TECHNICAL NOTE

File Ref: MA/PZ/P20-2187/05TN

Subject: Bacon Family – Deadline 5 Response

DRAWING TITLE:
SIZEWELL LINK ROAD B1122 / B1125 JUNCTION PROPOSED GENERAL ARRANGEMENT

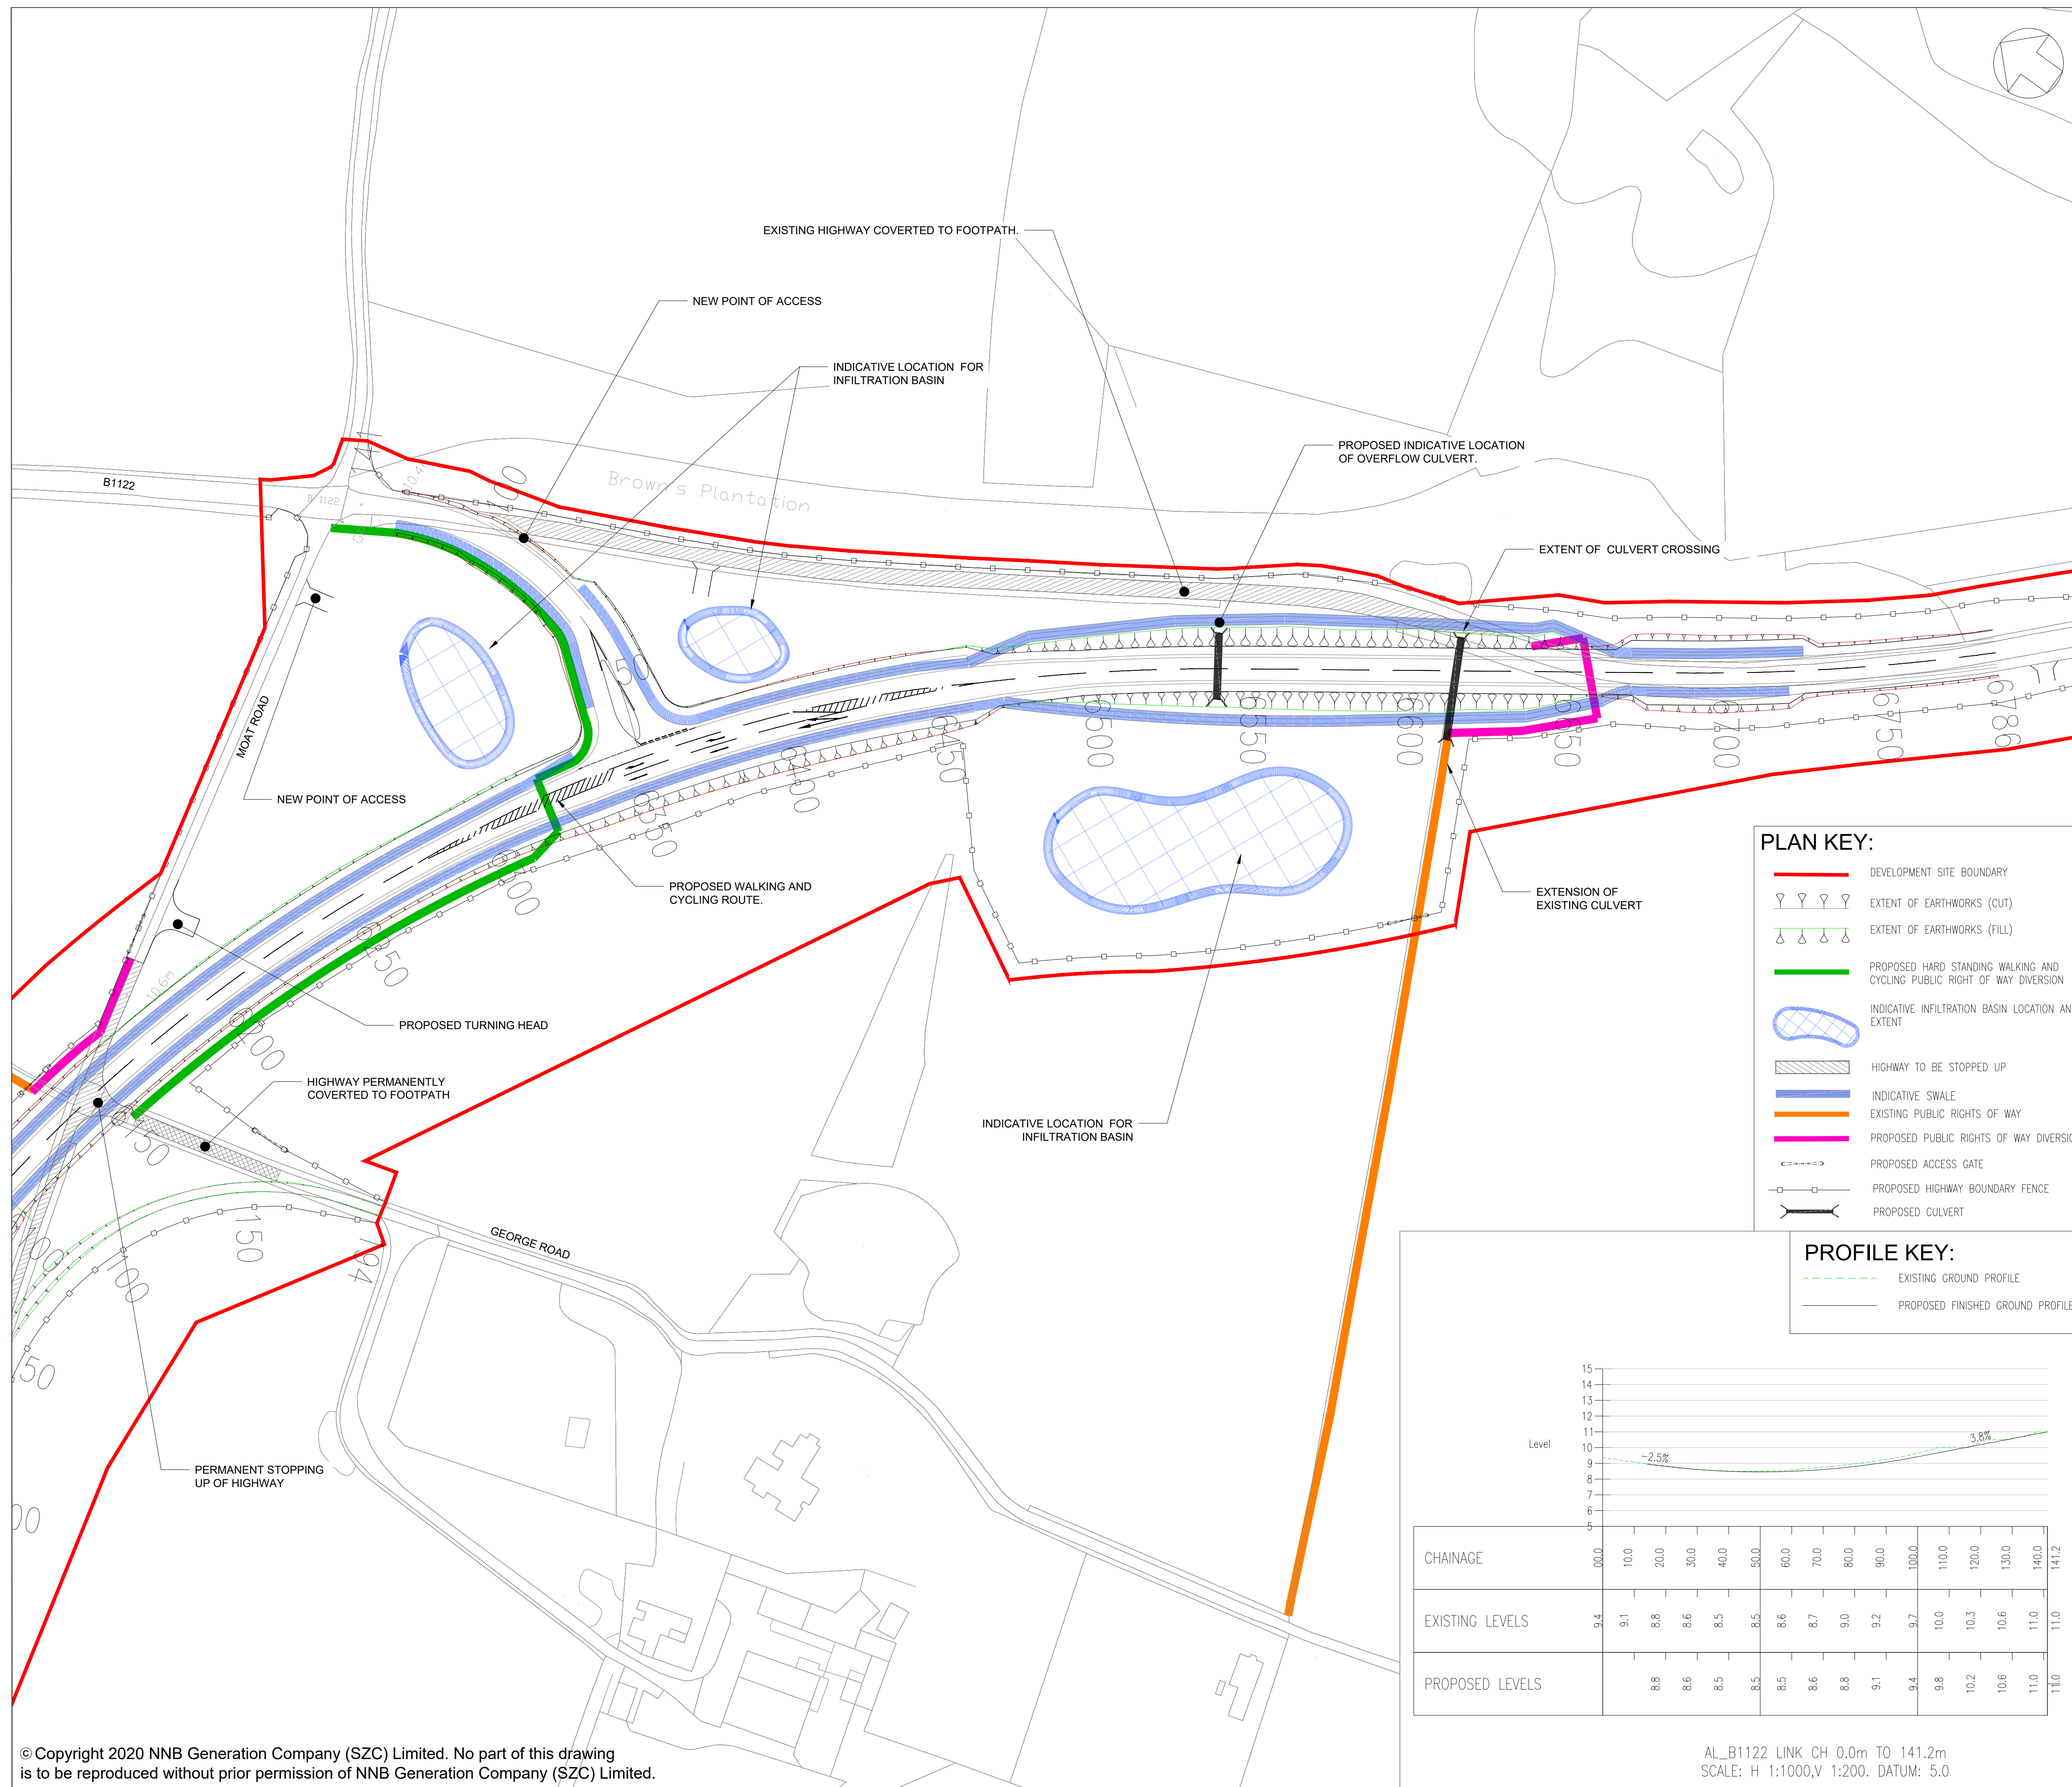
- 1.7. Figure 1.1 highlights the works proposed by the Applicant and the interface of the SLR, B1122 and B1125. The B1122 would be diverted, changing the current priority with the B1125 connecting directly to the SLR with a ghost island right turn lane junction arrangement.

- 1.14. Create are firmly of the opinion that should the current junction configuration remain as proposed it will continue to encourage Sizewell and general traffic along a route already prone to accidents with sub-standard alignment and lacking pedestrian amenity.

- 1.15. Taking this into account and the announcement by the Applicant to engage with Parties along the B1125, we feel the proposed junction configuration is now in direct conflict with the Applicants plans to introduce highway intervention measures along the B1125 and should be changed.

- 1.16. Create are looking to engage with the Applicant to alter the B1125 / SLR junction configuration. This will not only look to further discourage traffic along the B1125, but with the planned highway intervention measures suggested by the Application offer a significant legacy benefit.

- 1.18. The agreement by the Applicant to consider permanent highway mitigation works to improve pedestrian amenity and road safety is welcomed. This does not go far enough to offer a permanent legacy to residents along the B1125.
- 1.19. We believe the Applicant should remove the direct connection of the B1125 to the SLR, minimising the attractiveness of the B1125 to Sizewell traffic. Only with this would a true permanent legacy be achieved.

AL_FORDLEY ROAD CH 0.0m TO 148.7m
 SCALE: H 1:1000, V 1:200. DATUM: 5.0

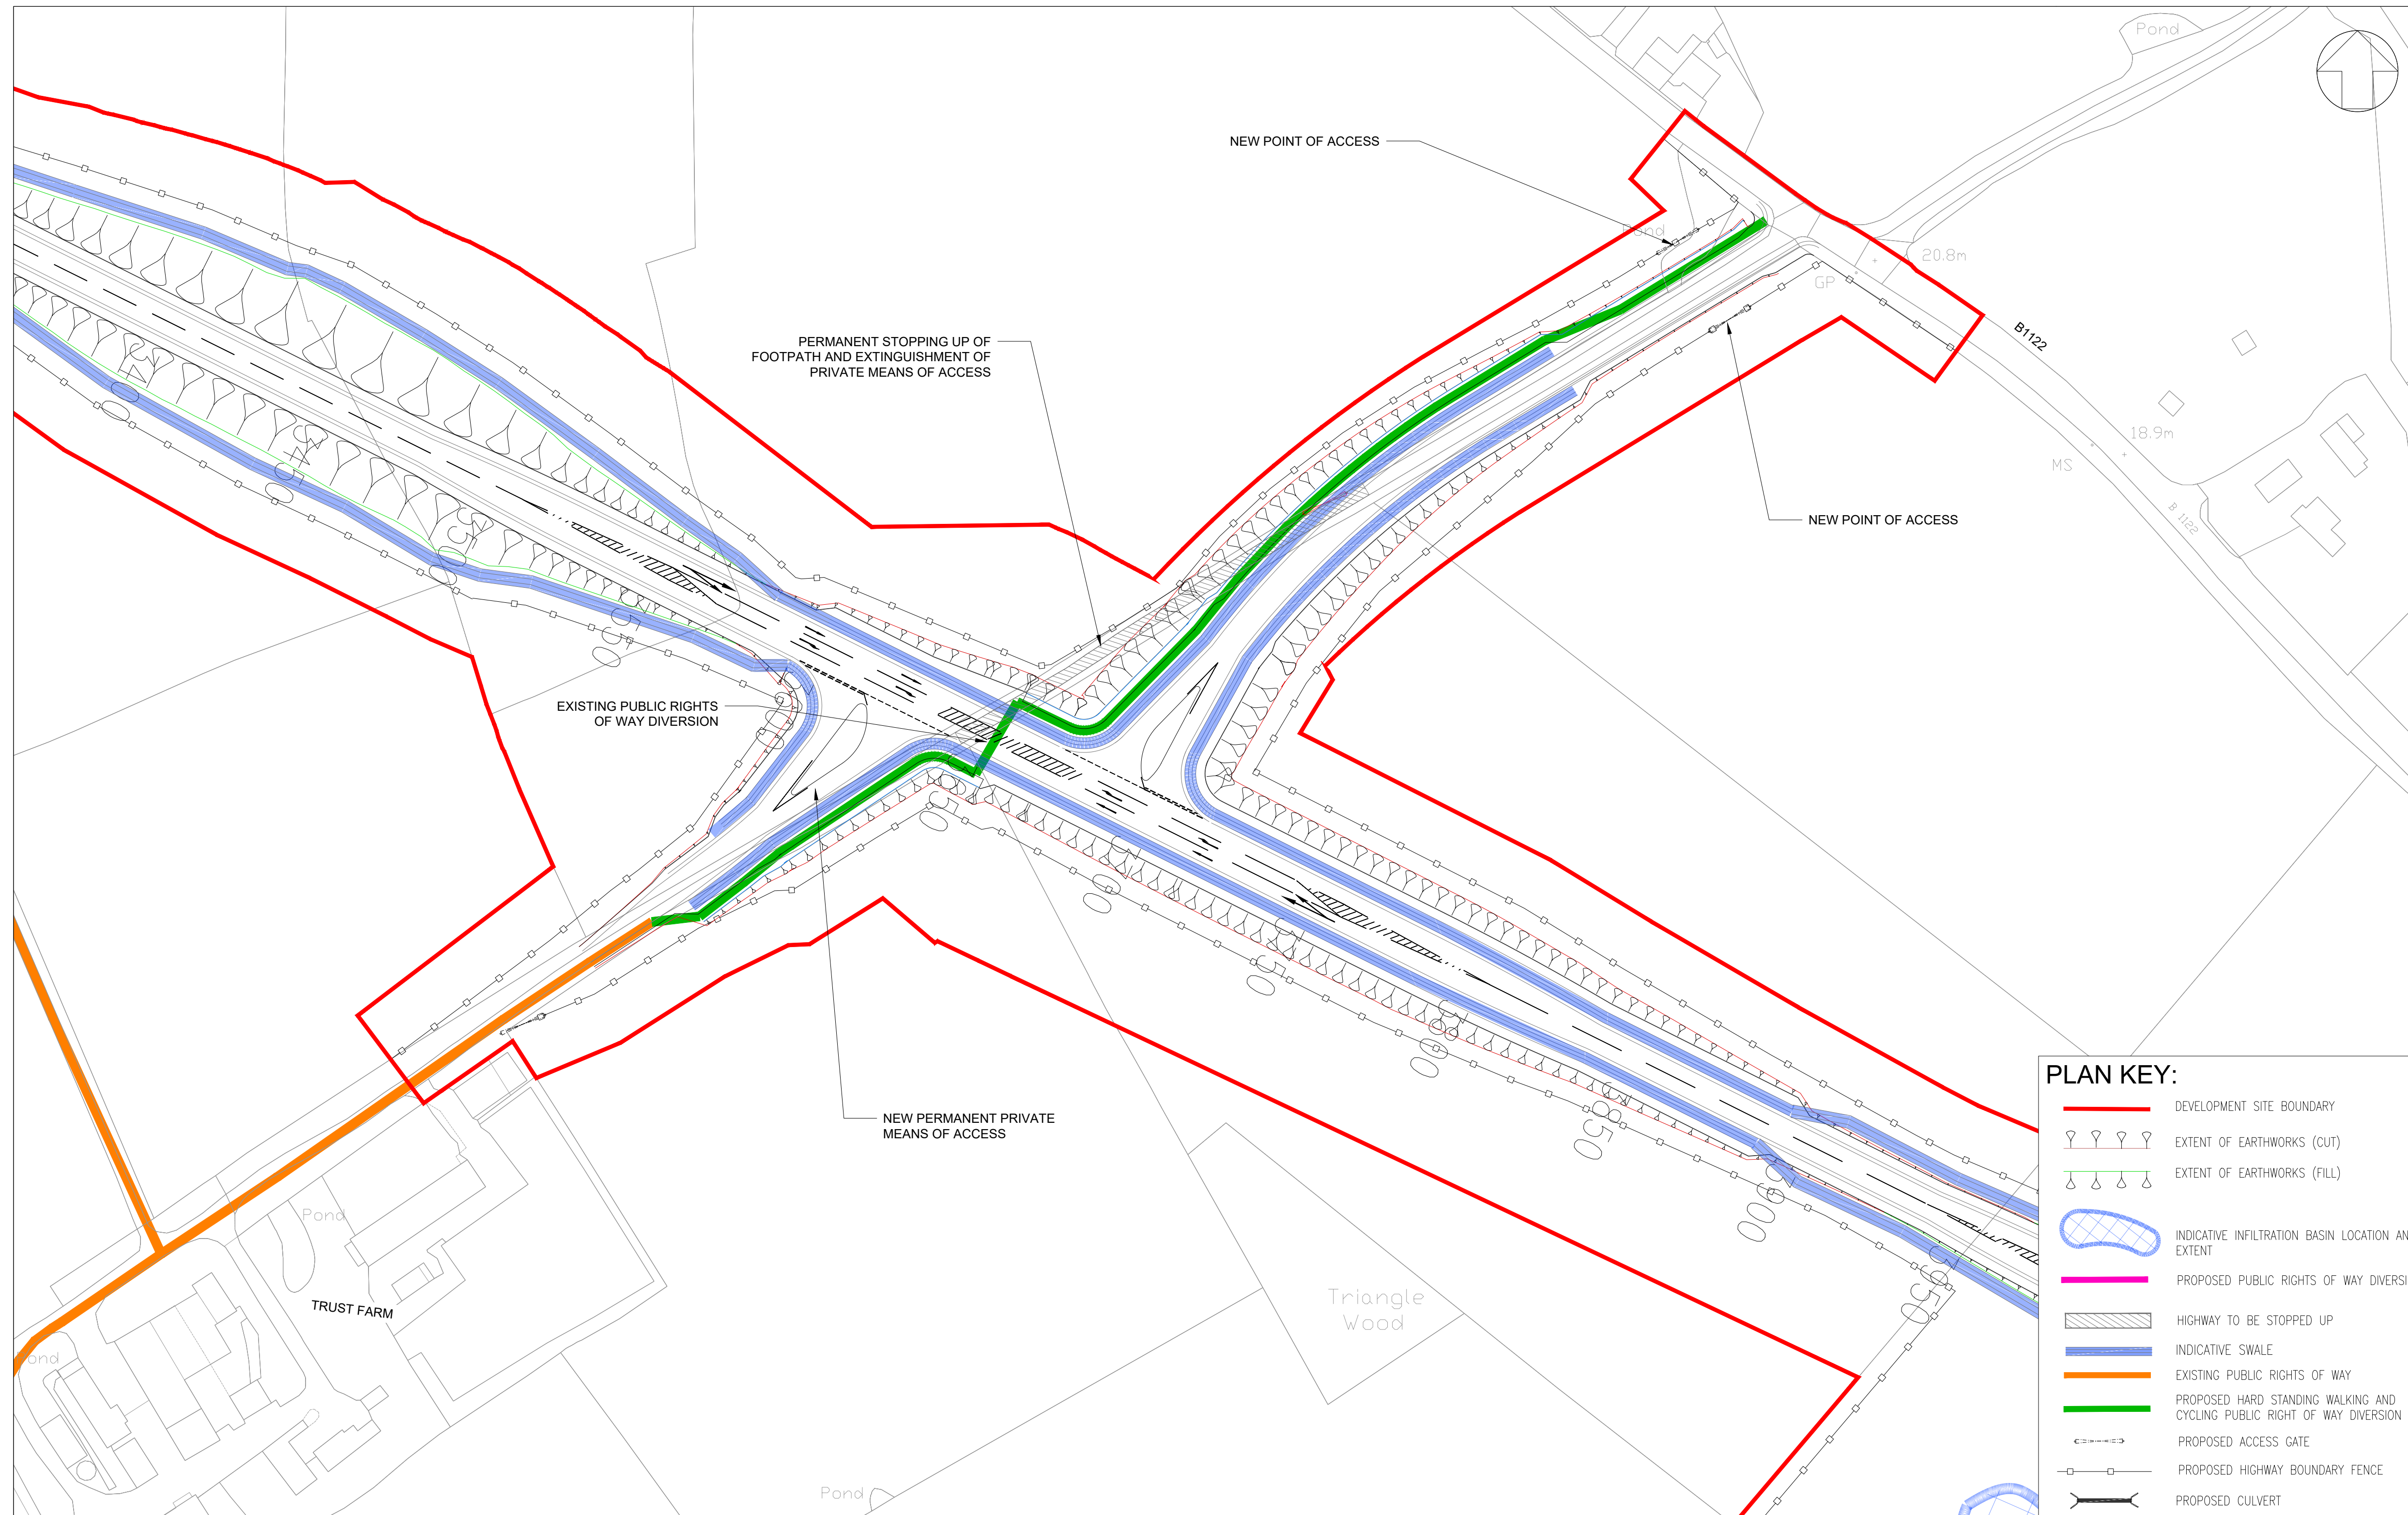
- Fordley Road engineering design, we understand options have been prepared by the Applicant, which considers the Fordley Road change to remove the SLR connection, whilst maintaining Fordley Road.

We understand from meeting minutes between Middleton cum Fordley Parish Council and EDF dated 5th July 2021 that the Applicant has dismissed this possible legacy option on technical grounds, a matter which is strongly disputed.
